Memo To: Jean Fraser
Barbara Barhydt
From: David Margolis-Pineo
RE: Development Review Comments for 118 Congress St.

The Department of Public Services has the following comments for the proposed project located at 118 Congress Street.

2 BRICK DRIVEWAY APRON WITH BITUMINOUS BASE (I-11)  
NOT TO SCALE

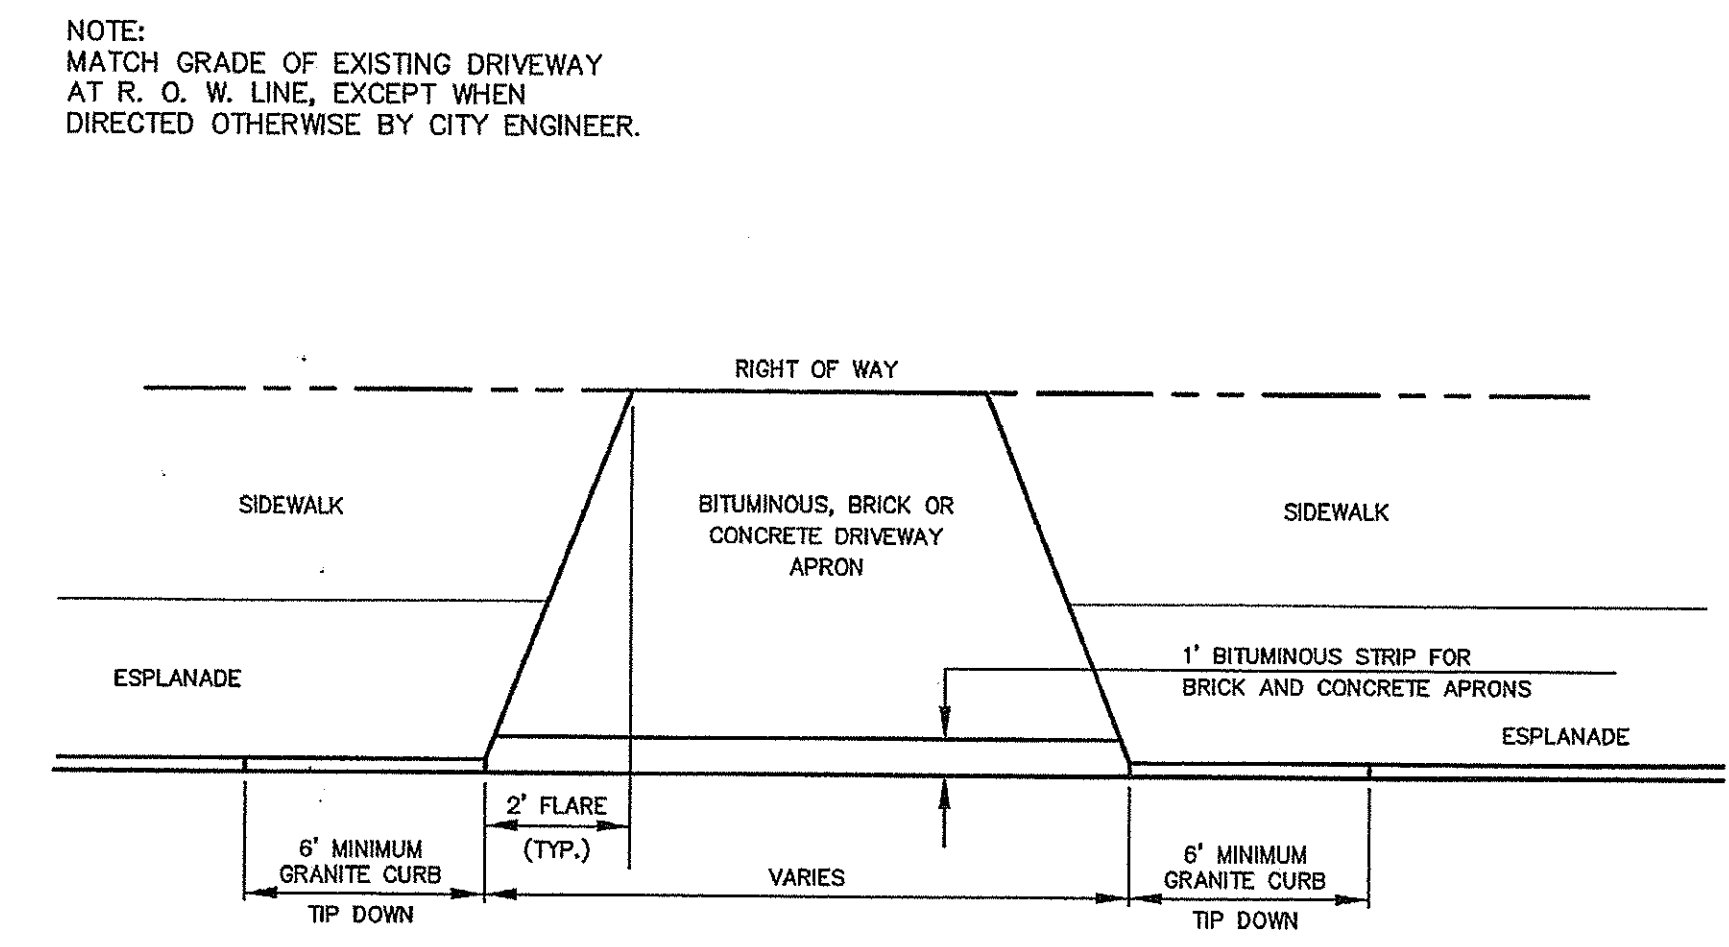
6. The proposed back decks encroach the set back.
Revised design addresses this.
7. The proposed curb cut currently shows a brick apron. The City's Technical Manual requires asphalt drive aprons.
Not addressed.

8  
L2.0  
NOT TO SCALE  
GRANITE PAVER SECTION - MAIN BUILDING ENTRIES

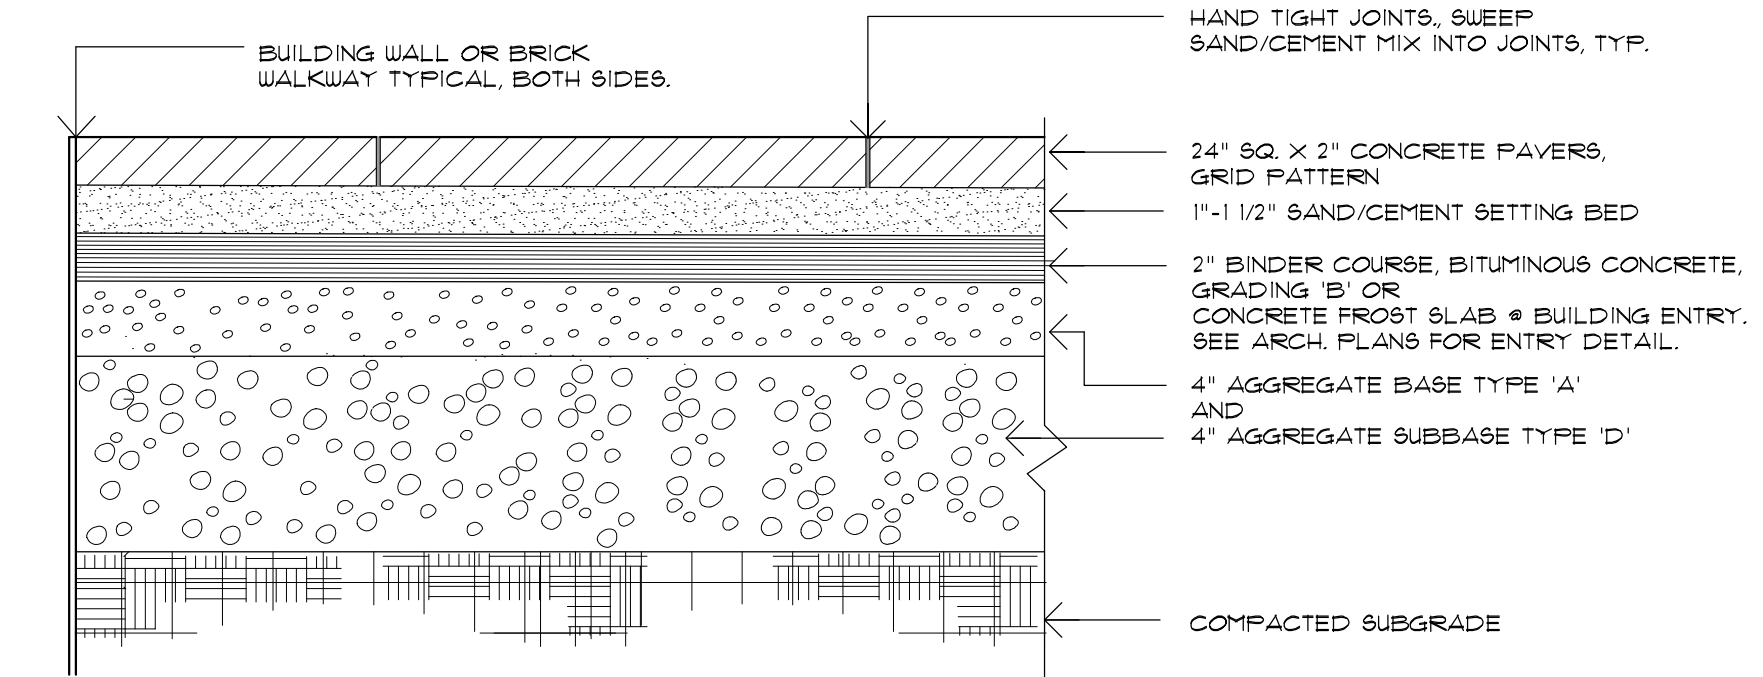
13. **The Subdivision Recording Plat is required to be stamped by a registered Land Surveyor.**
14. **The applicant is proposing flush granite and concrete pavers in the sidewalk area within the road right of way. This Department is not averse but the City Council will need to OK the request change of sidewalk material which goes against City policy.**
